SIGN PLAN | SIZING

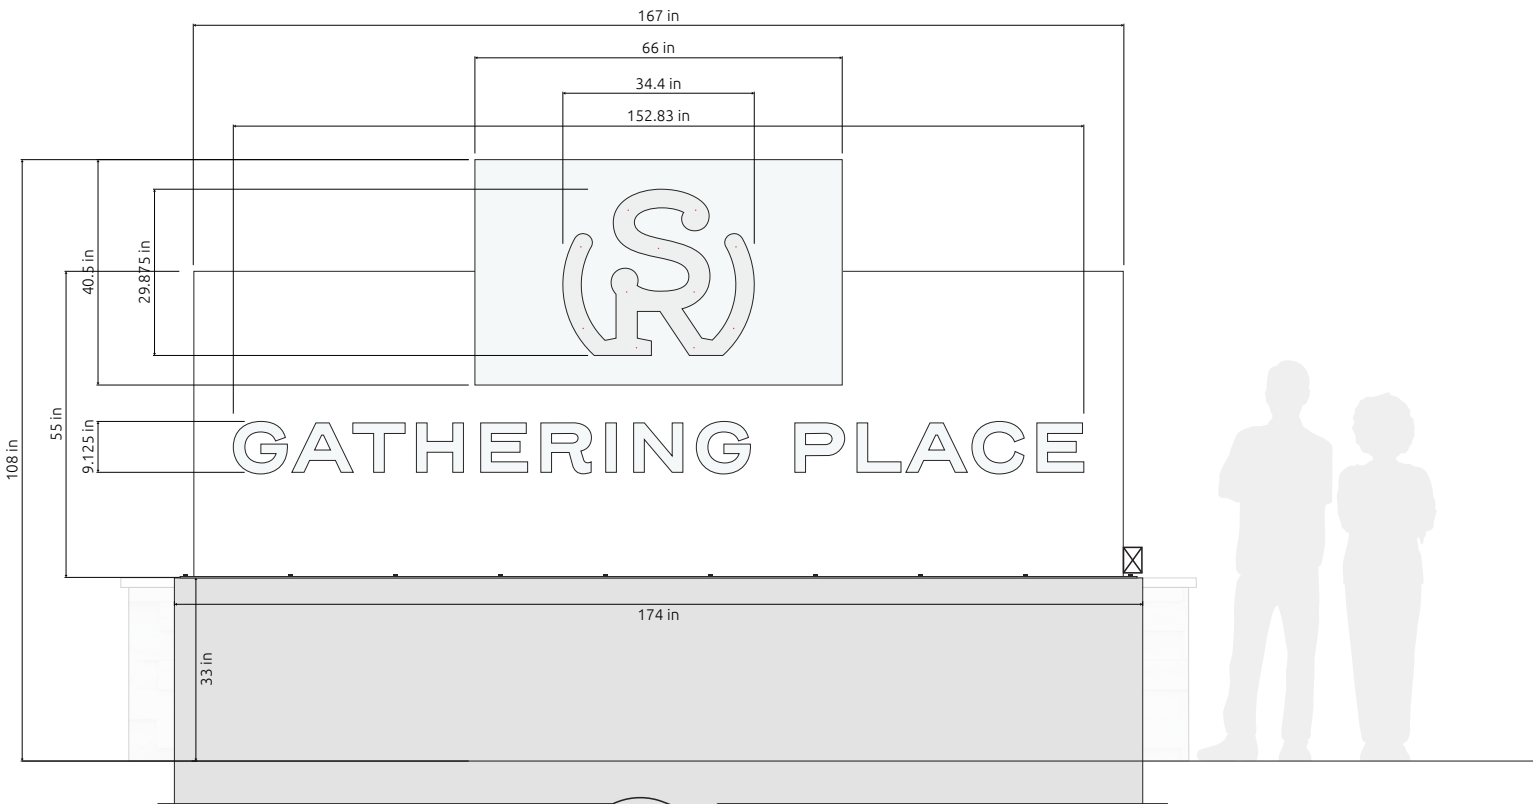
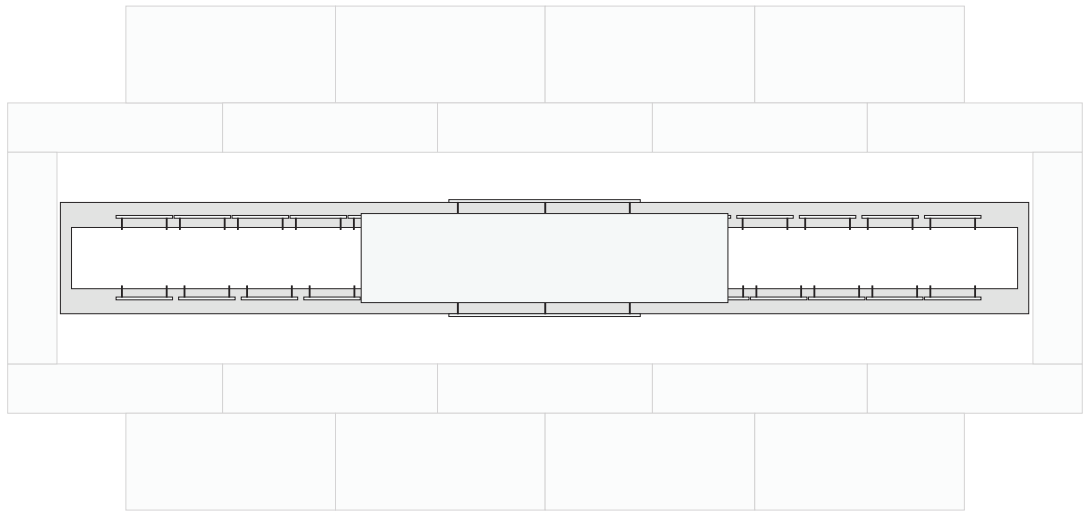
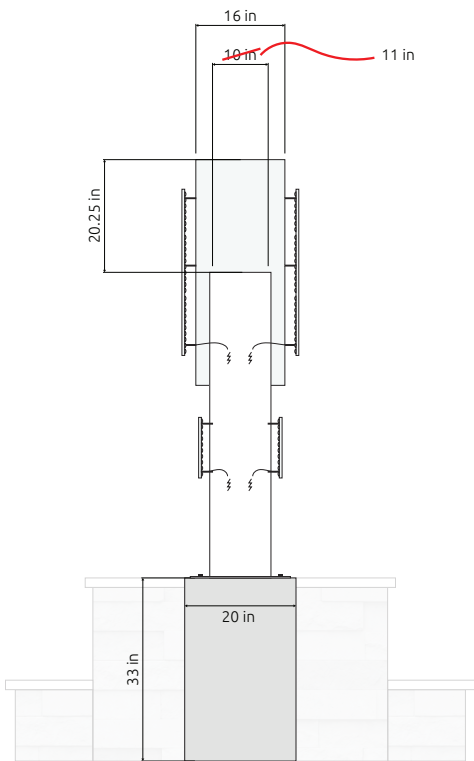
There only appears to be one sign on the site plan. Please correct this or show the other 3 signs on the site plan for review

All identification signs shall be low-profile and shall not exceed 6 feet in height.

SITE PLAN

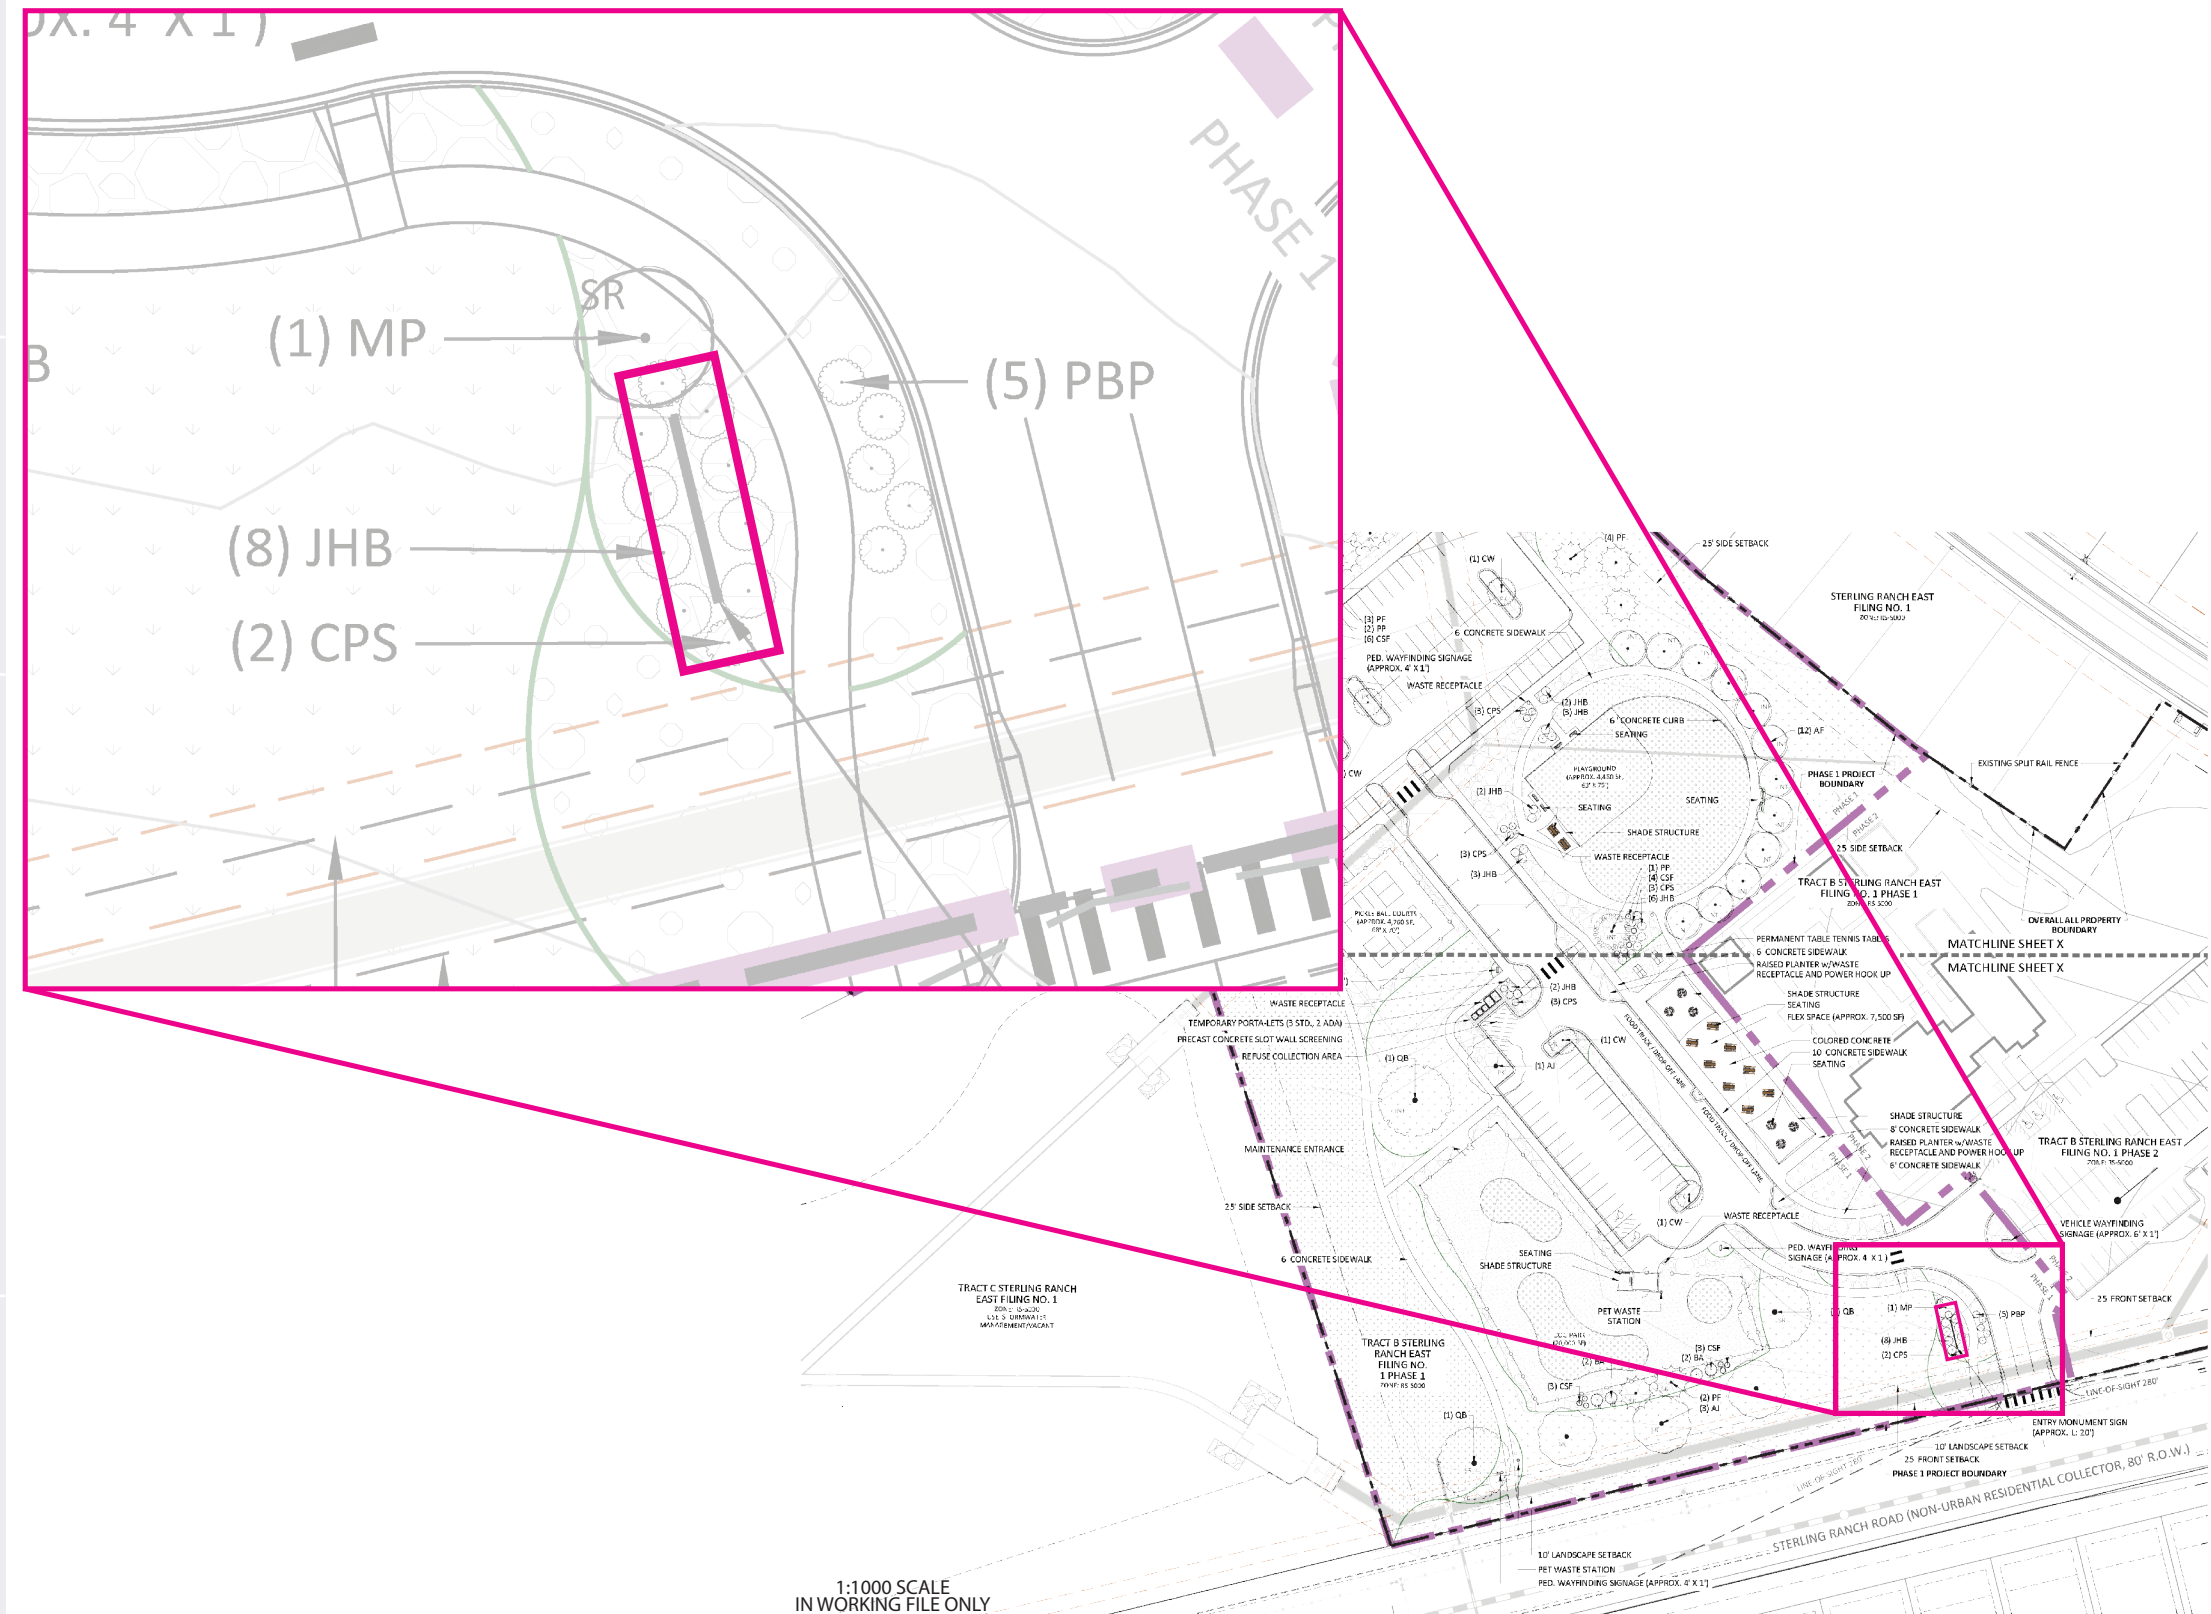
this is not the correct address for this sign application. Please use 8440 Sterling Ranch Rd

There only appears to be one sign on the site plan. Please correct this or show the other 3 signs on the site plan for review

Please indicate the distance from the sign to the property boundary. Identification signs shall be located at least 25 feet from all lot, parcel, or tract lines adjacent to public and private rights-of-way or easements.
